Ref: D2017/74146

Wallerawang Quarry Modification 1 (DA 344-11-2001 MOD 1)

I refer to your email received 6 June 2017 requesting WaterNSW to provide comment on the Environmental Assessment (EA) for the Wallerawang Quarry Modification 1. WaterNSW appreciates the opportunity and offers the following comments for consideration.

Figure 2
QUARRY SITE LAYOUT

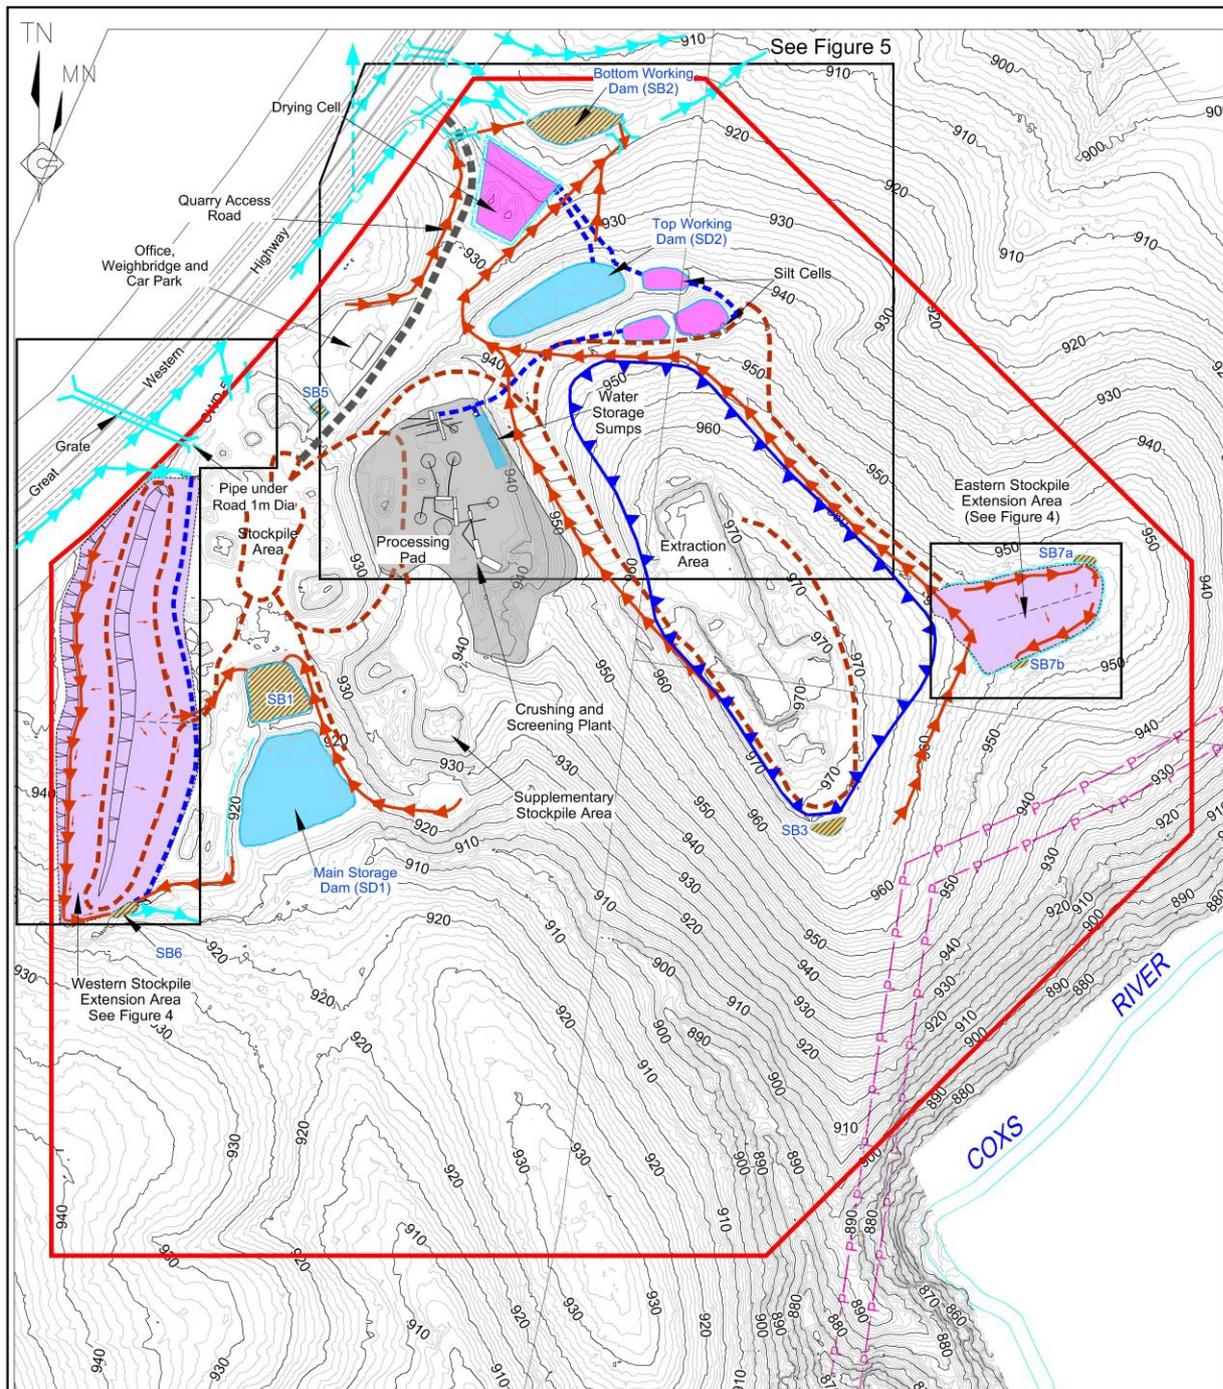
WaterNSW notes that the silt dams, sediment dam (SB3) and some dirty water diversion drains in Figure 2, Page 3 of the main report appear to be within the approved extraction area as shown in Figure 8, Page 31 of the main report. WaterNSW requests that the updated Water Management Plan address this matter.

WaterNSW recommends that the Department modify Condition 2.29 of the consent as follows:

- Before the modification works are implemented, the Water Management Plan shall be updated in consultation with Water NSW.
